| Application reference number | 2024/0999 |

| Proposal Description: | Erection of 2no. detached 2-bedroom dormer bungalows |
| Location: | Land adjacent to 20 Bismarck Street, Worsbrough Common, Barnsley, S70 4NA |

CLIENT:	Mr Mick Miller.
SITE ADDRESS:	Land adjacent to: Bismarck Street, Barnsley, S70 4NA, South Yorkshire.
PROJECT:	Proposed Residential Development.
SCALE:	1:100 @ A3
TITLE:	Plot 1 Elevations as Proposed.
DATE:	September 2024
Drawing Number 24-05A Ref: MILLER

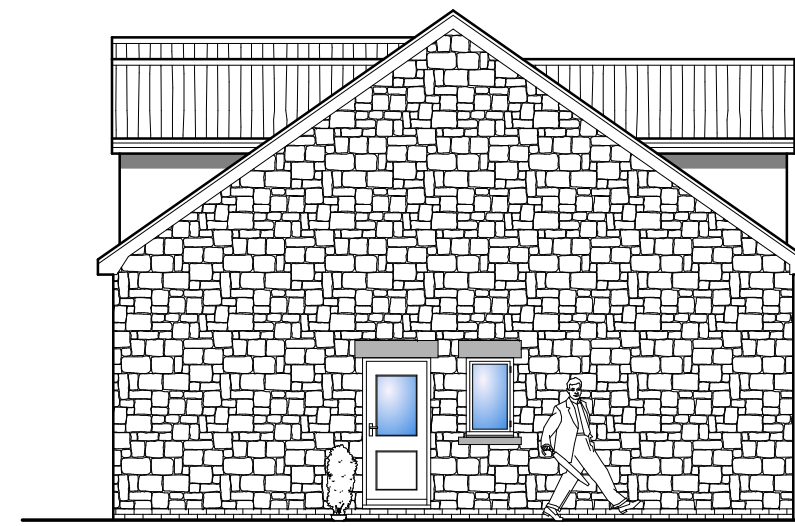
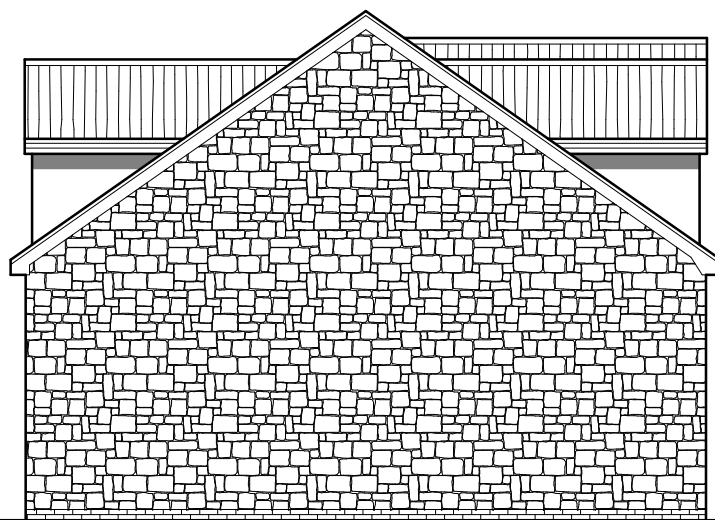
The design of the dwellings has been amended during the application process, by increasing the eaves height and reducing the ridge height to create a more balanced design and to avoid the dwellings appearing 'top heavy'

The eaves height was increased and the ridge height reduced to create a more balanced design and to avoid the dwellings appearing 'top heavy'
